WEST SUSSEX COUNTY COUNCIL CONSULTATION

TO:	Arun District Council FAO:Simon Davis
FROM:	WSCC - Highways Authority
DATE:	11 April 2019
LOCATION:	Mow Cottage Worms Lane Felpham
SUBJECT:	FP/64/19/PL Replace burnt down cottage with a similar sized single storey property - This is a Departure from the Development Plan.
DATE OF SITE VISIT:	n/a
RECOMMENDATION:	Advice
S106 CONTRIBUTION TOTAL:	n/a

SITE PLAN 1:500 @ A3

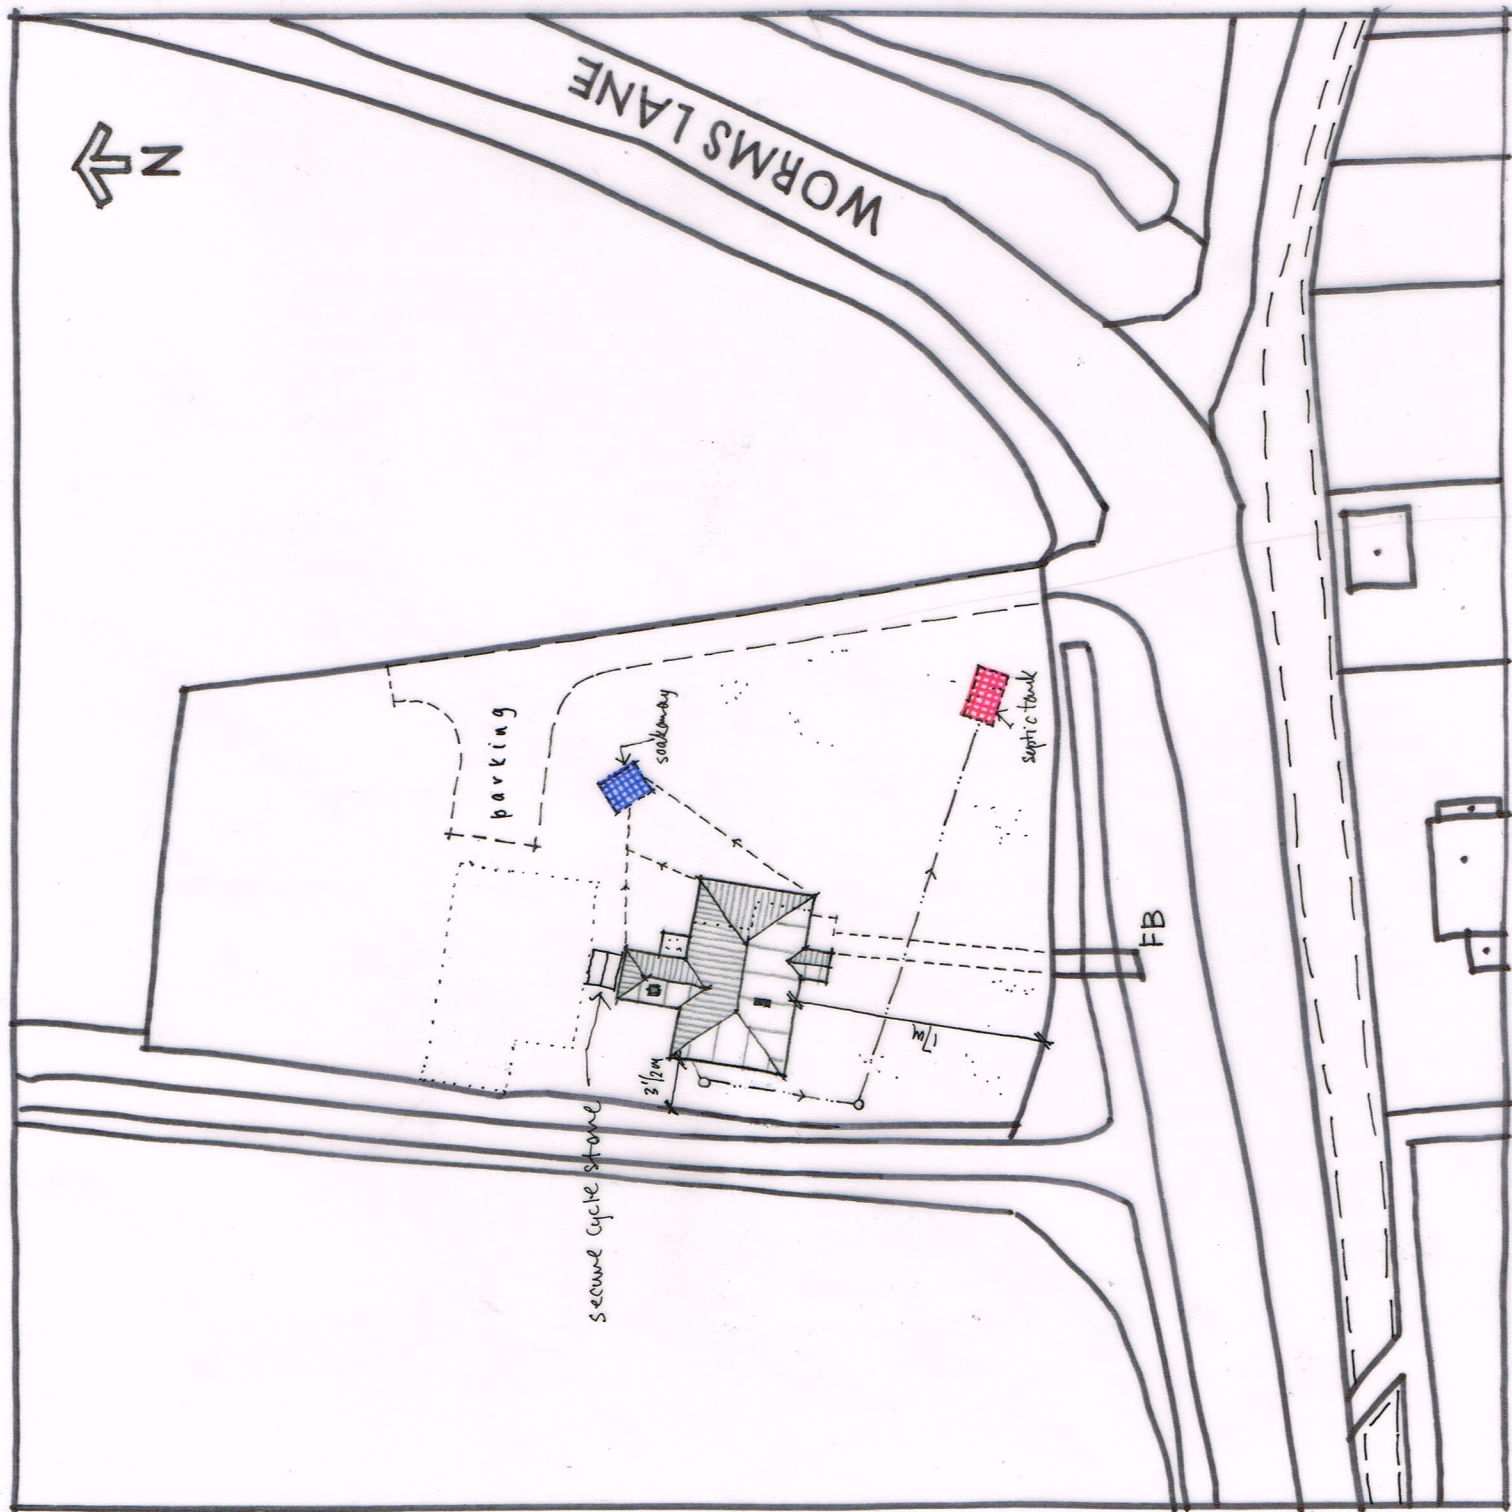
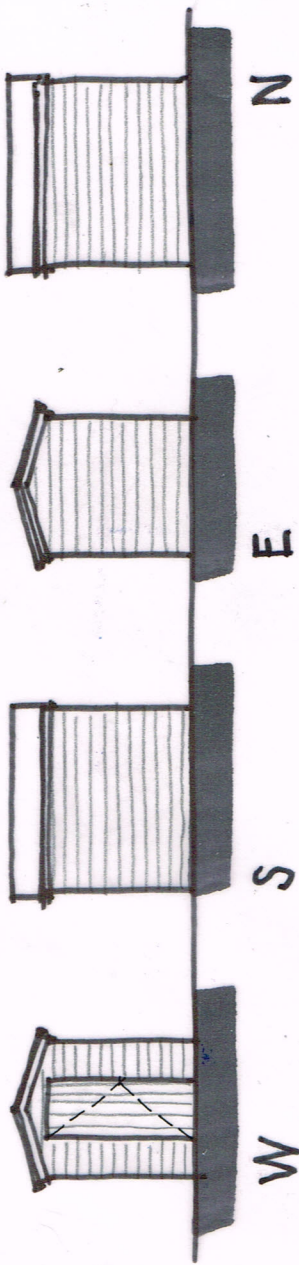
The current proposed plans meet the Vehicle Parking standards and Cycle Parking Standards set out by WSCC.

The plans do not show any refuse and recycling collection arrangements, although Manual for Streets does state that residents should not have to travel over 30m to put bins out and collection vehicles should not have to travel in excess of 25m to collect/deposit bins. This is however a matter of amenity for the Local Planning Authority (LPA) to consider. The applicant is advised to contact the waste disposal authorities to ascertain whether the practise would be acceptable.

No part of the development shall be first occupied until the car parking has been constructed in accordance with the approved site plan. These spaces shall thereafter be retained at all times for their designated purpose.

No part of the development shall be first occupied until covered and secure cycle parking spaces have been provided in accordance with plans and details submitted to and approved by the Local Planning Authority.
